SUBMISSION FOR APPLICATION No. SSD5752

Please find the submission below that OBJECTS to the current Development Application SSD5752.

I am an owner in the Goldsbrough, a residential building of approximately 500 apartments, which is located directly behind the proposed ICC Convention centre.

ICC CONVENTION

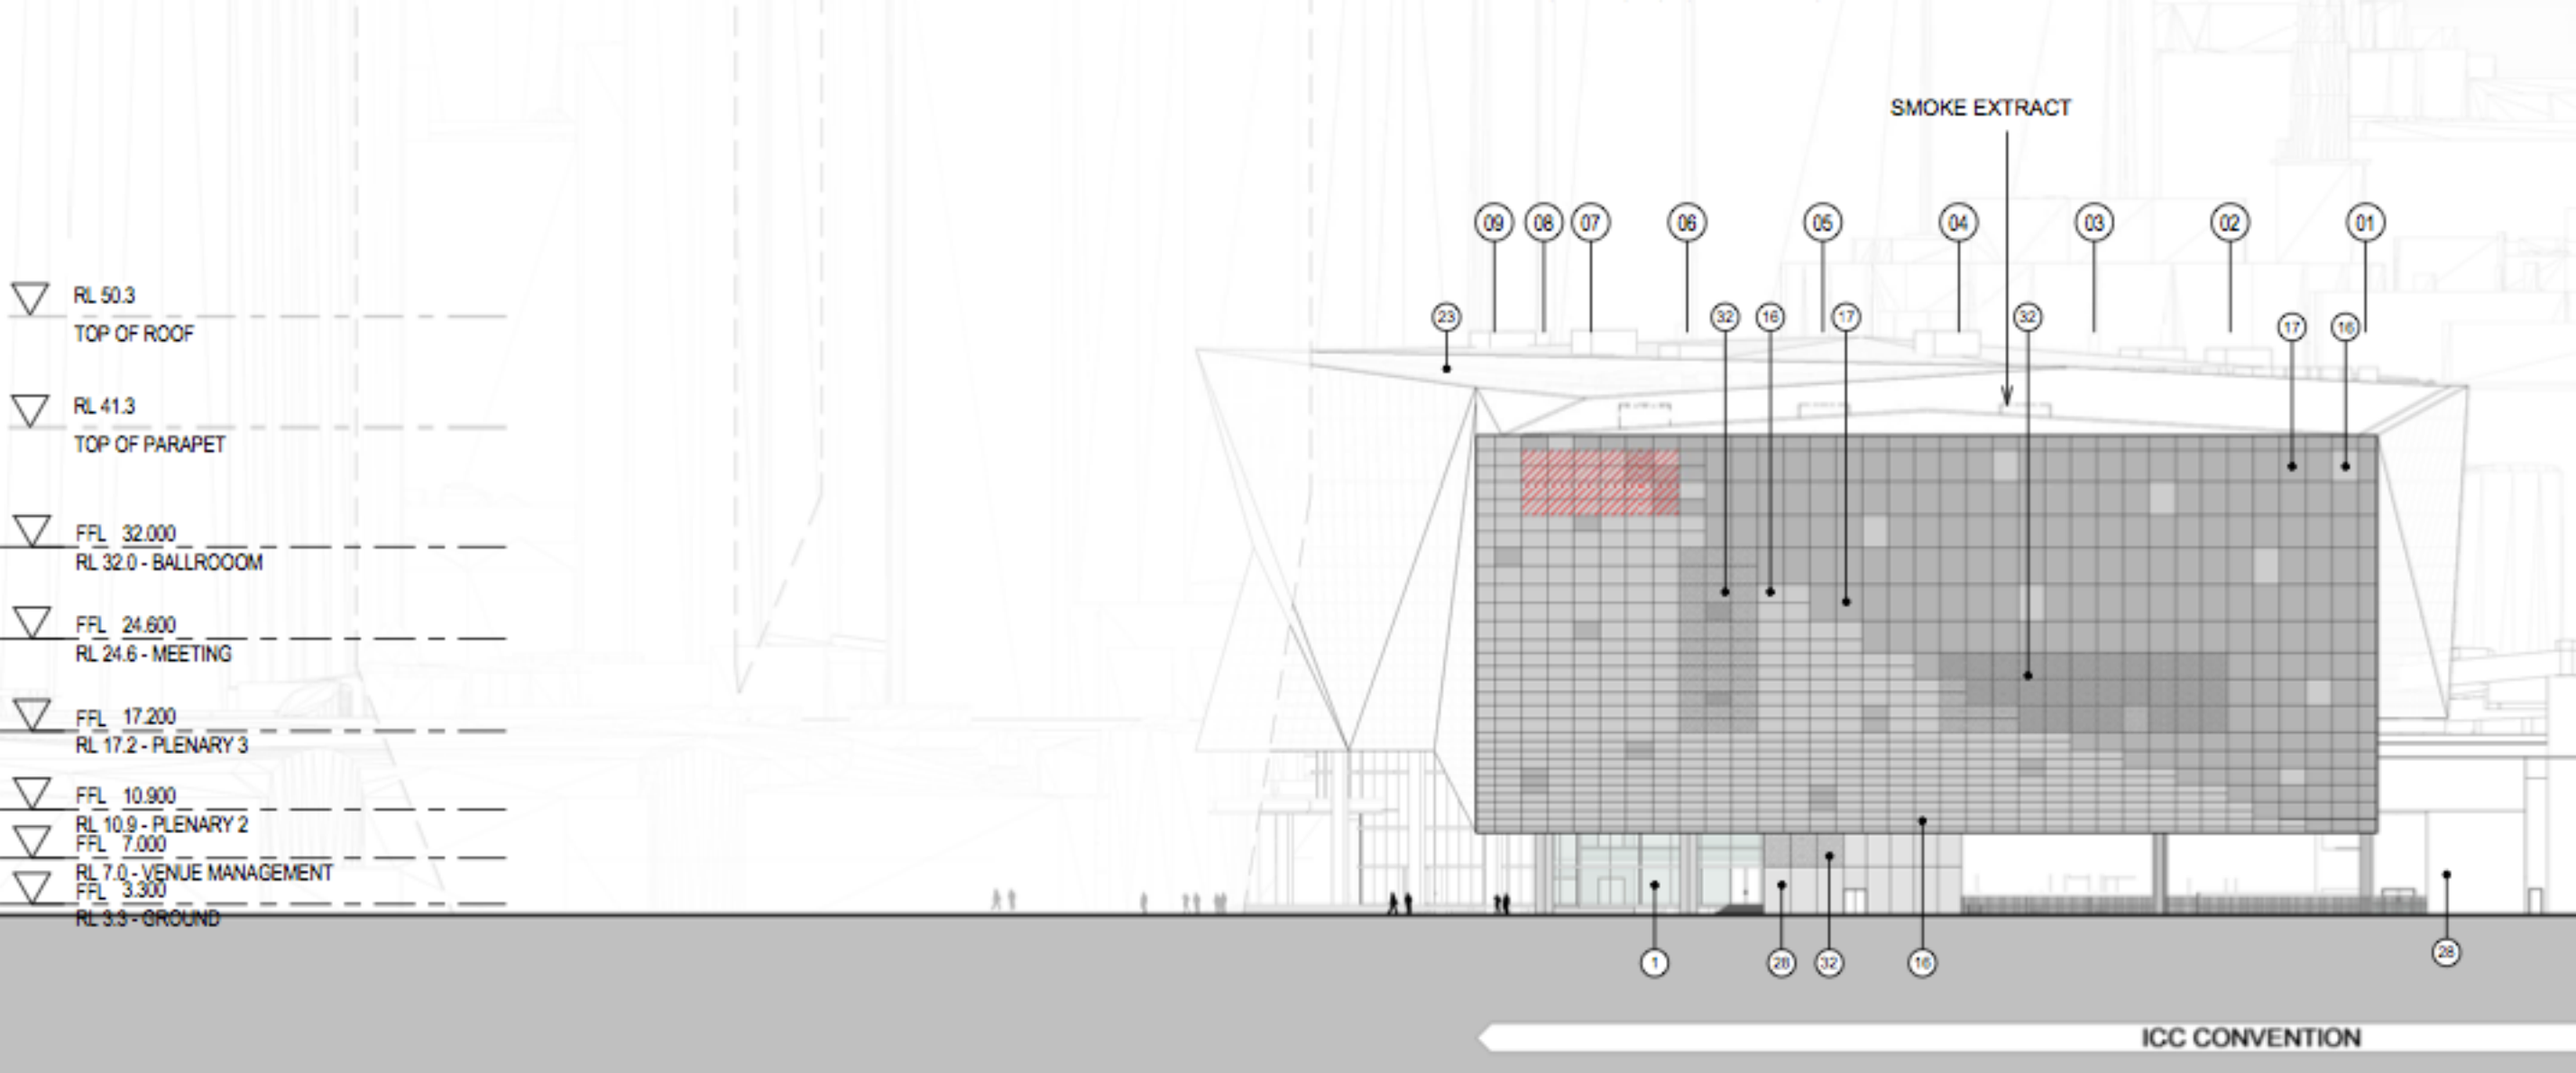
We firstly object to the height of the proposed new ICC convention centre which is nearly to the top of the Goldsbrough's current height.

In the DA plans the proposed height is RL 50.3 which will block the entire view to Darling Harbour and the city from the Goldsbrough's eastern facing apartments. There is supposed to be a concept of view sharing in the city but in this case the whole of the eastern view of the Goldsbrough will be blocked out by the new ICC convention centre.

In place of the current city skyline and Darling Harbour view there will be a flat blank metallic wall in its place, which is the rear of the proposed ICC convention building. The front of the ICC building looks to be nicely designed with glass and is broken up in angles, but the Goldsbrough will be facing an ugly flat back wall made of aluminum and mainly Grey.

Please see the diagram of the back of the ICC convention centre below , which will be approximately the same height as the Goldsbrough.

DRAWING TITLE
 GA PLANS - LOBBY - LEVEL 0 (RL 3.3)

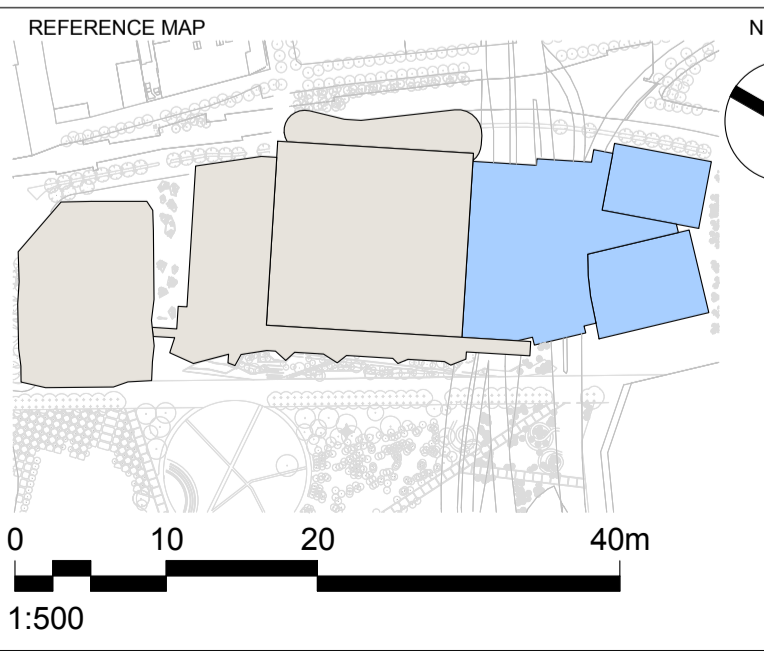
The proposed changes at Darling Harbour seem to take away an extremely important thoroughfare for the residents and guests of the Goldsbrough. From the plans it looks like the current overhead pedestrian walkway next to the Convention monorail station is being removed. Currently it is the easiest and safest walkway to enter the Darling Harbour precinct from the Western side.

The alternative link from the Western Distributor is not a convenient alternative to what is currently there. How are pedestrians especially with children meant to cross to and from Darling Harbour in a safe way at all hours ?

From the Architectural drawings below it shows how the current walkway is removed in the proposed plan

This is the walkway being removed
